**Subject:** Planning ref: 20/00574/F (Additional comments). Land North of Hill Farm Hill Farm Lane Duns Tew OX25 0JJ.

**Planning ref: 20/00574/F (Additional comments). Land North of Hill Farm Hill Farm Lane Duns Tew OX25 0JJ.**

**Planning ref: 20/00574/F. Land North of Hill Farm Hill Farm Lane Duns Tew OX25 0JJ.**

| Drawing Title: | Security Fencing |

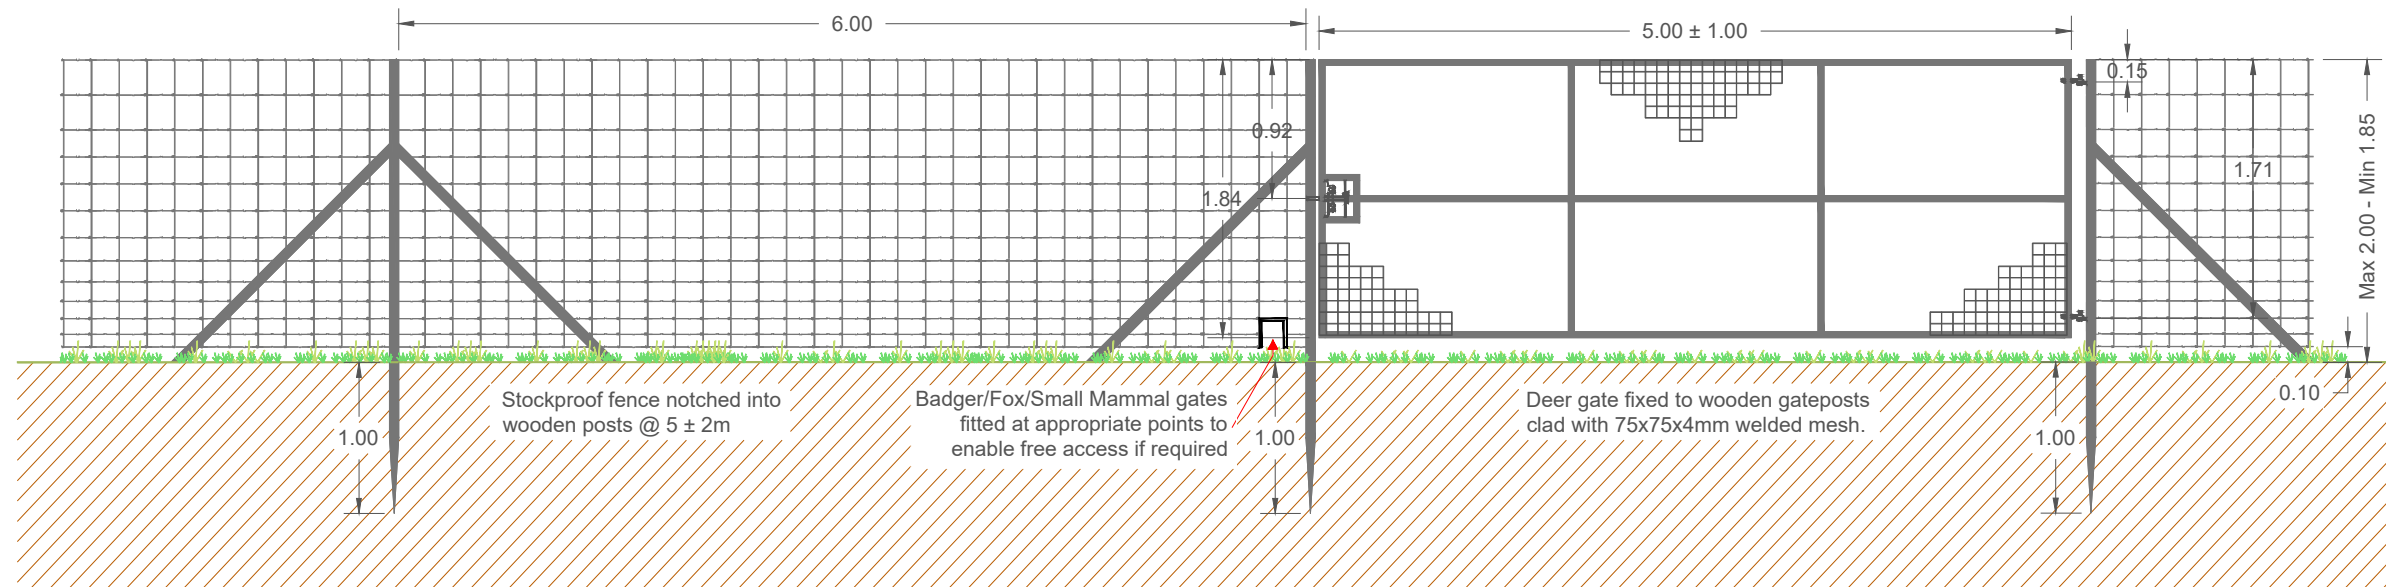
The proposed fencing may well be used widely and meet the broad requirements of planning policy, but the fact remains that it is not a security rated fence and is therefore more susceptible to being breached. CCTV being monitored and a response team being available are also of help, but my advice is based on improving what is proposed to a level of security which is more likely to deter and prevent crime.

I am pleased to see that a security fence is proposed to protect the installations. This is appropriate, given the size of the proposed site that it could become a high value target for precious metal theft etc. However, I feel the specified fencing does would not be robust enough to prevent unauthorised intrusion. Therefore, I recommend that a higher specification that the requirements of LPS1175, Issue 8, B3, is used instead and that the applicants also incorporate a monitored perimeter intruder protection system (PIDS) to work in conjunction with the CCTV already proposed.
